Access Assessment Report

Richmond Centre of Excellence

Reference No: 113050C-Access-CoE-r2

Date: 28 April 2021

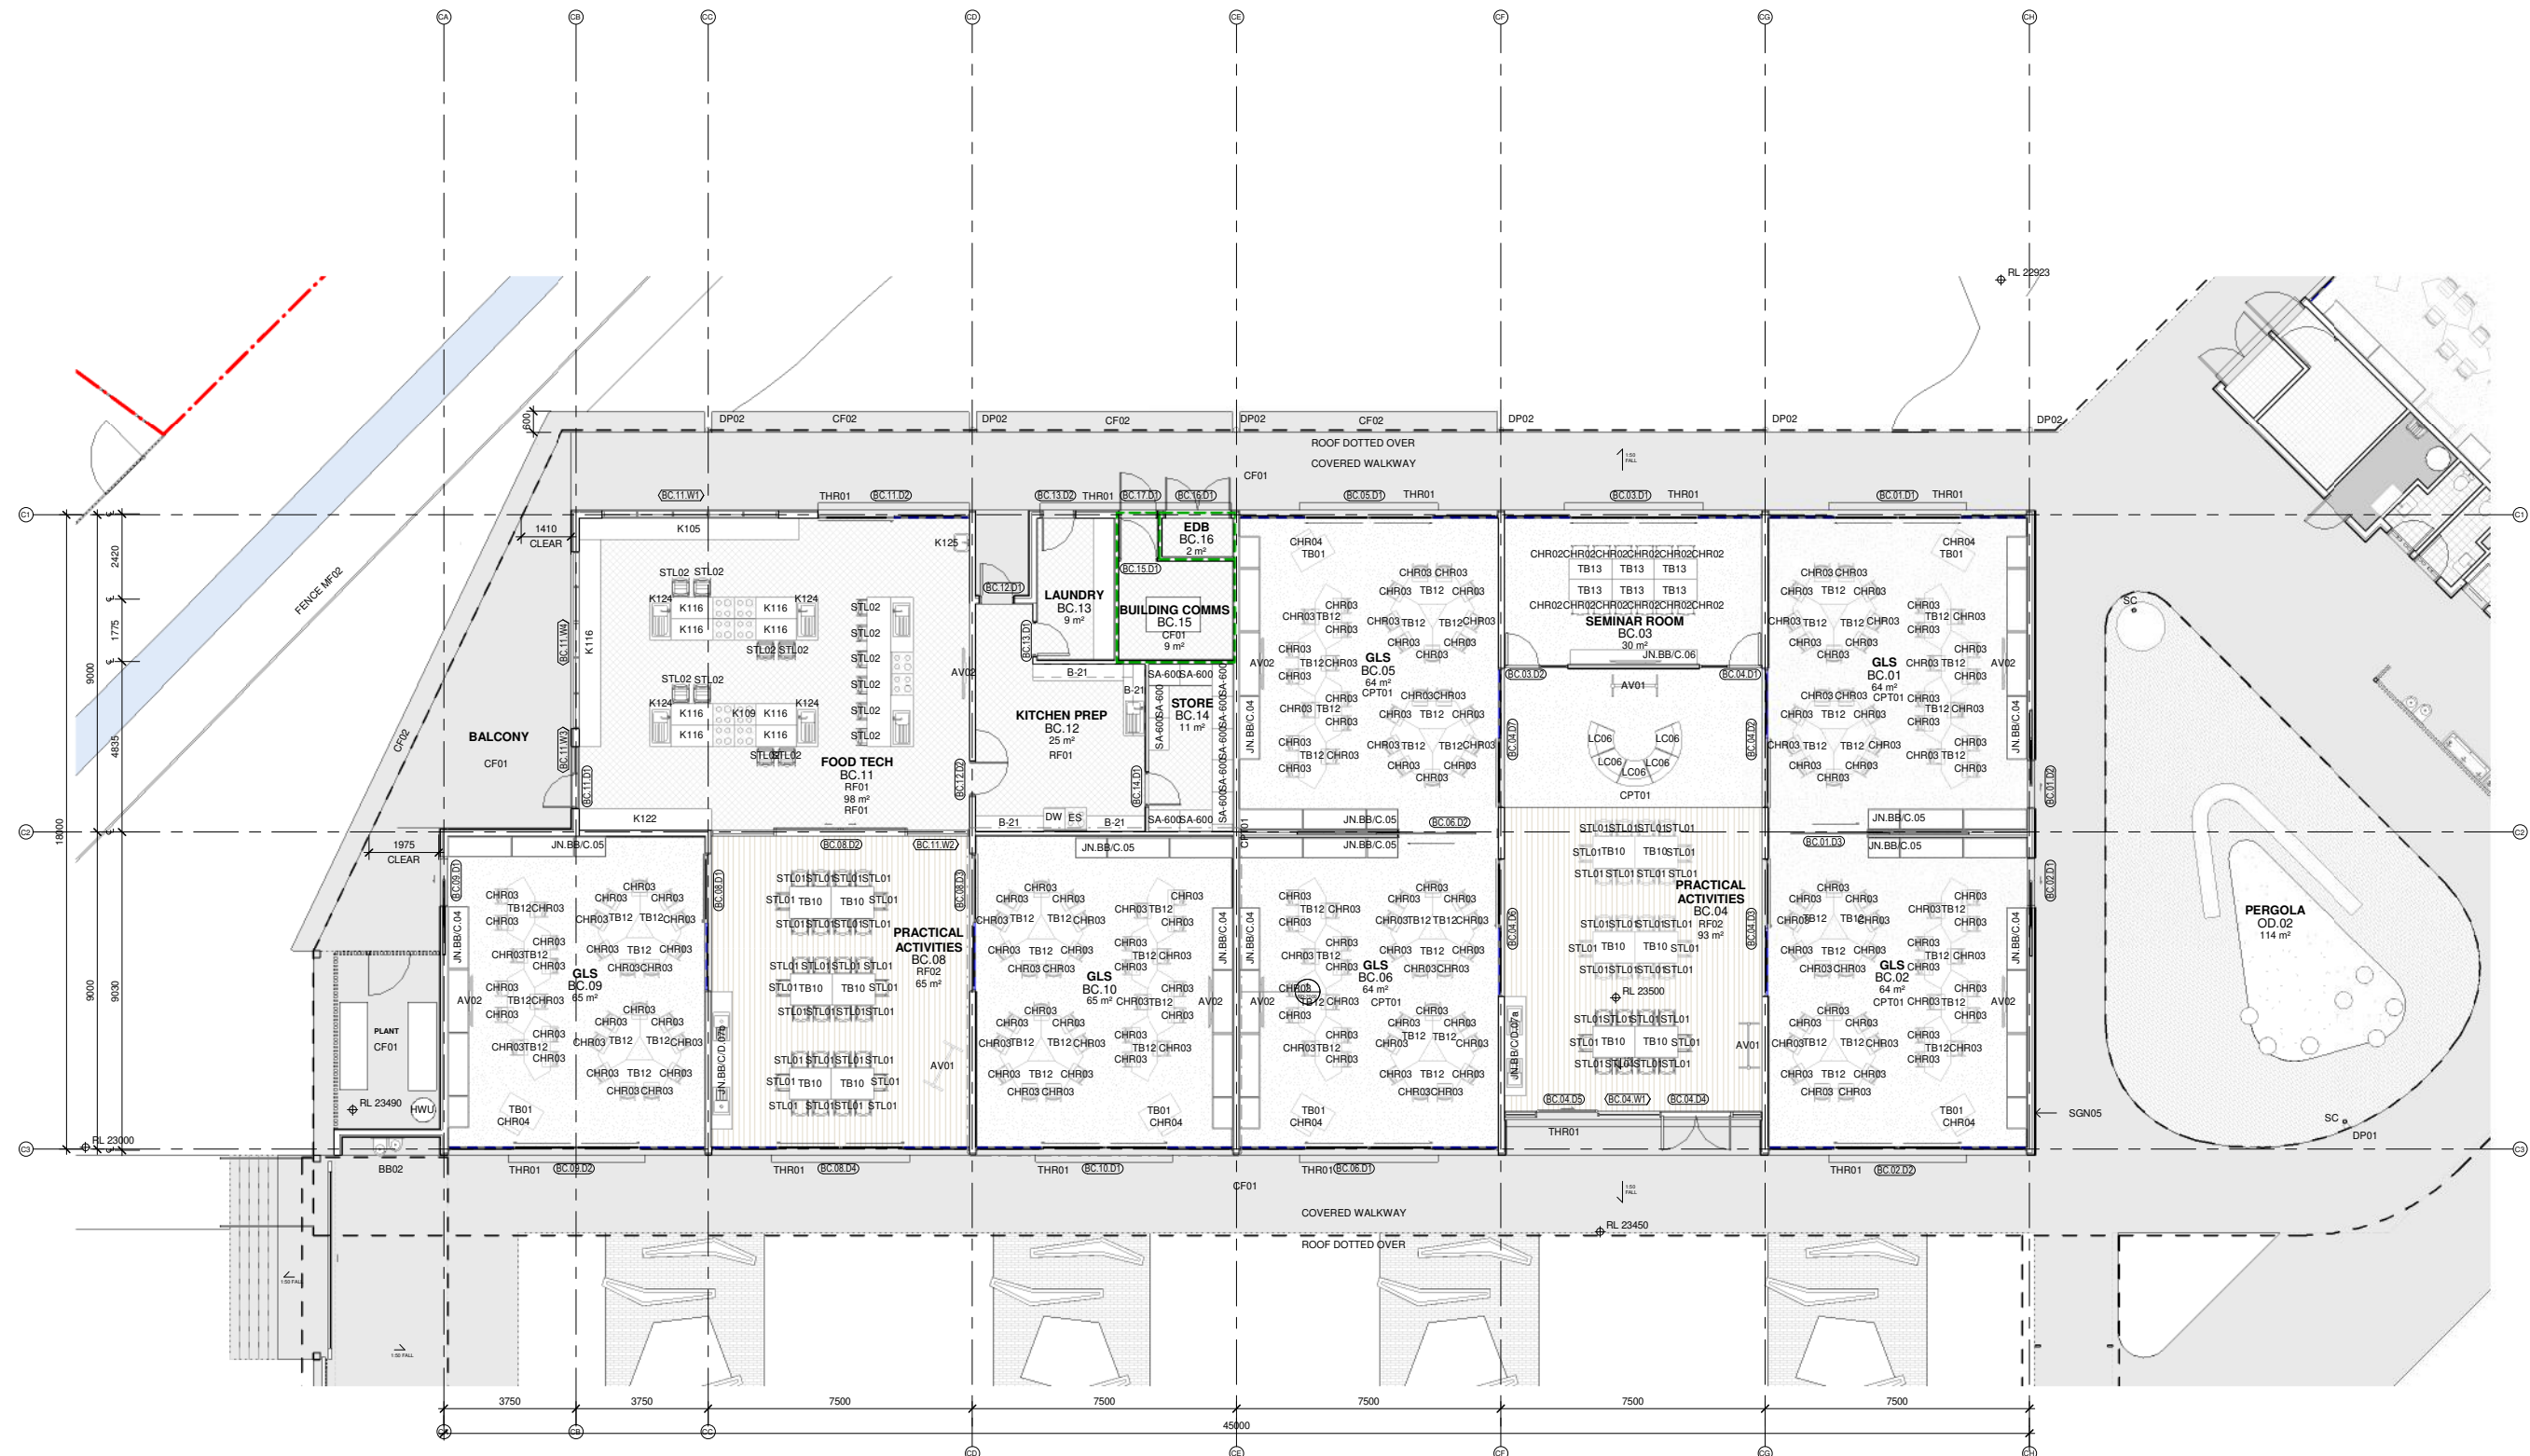
- (a) Accessible entry / doorways into each Block: Design team to consider and identify the accessible entry doors into each block and the accessible doors between learning spaces within each Block.

- Block C is an example below/
 - Is accessway provided into Practical Activities then via internal accessible sliding doors into each GLAS? Refer Green lines below.

- External sliding doors have challenges to being accessible: must have flush thresholds and have no more than 20N opening force. Weather protection at thresholds?

- Internal sliding doors can generally be hung from top rail for flush thresholds and more likely to achieve no more than 20N opening force for top hung doors with the correct sliding door hardware. Although, these internal doors are large, and consideration should be given how to achieve 20N opening force.

- Architect to nominate accessible entry doors and pathways within buildings.
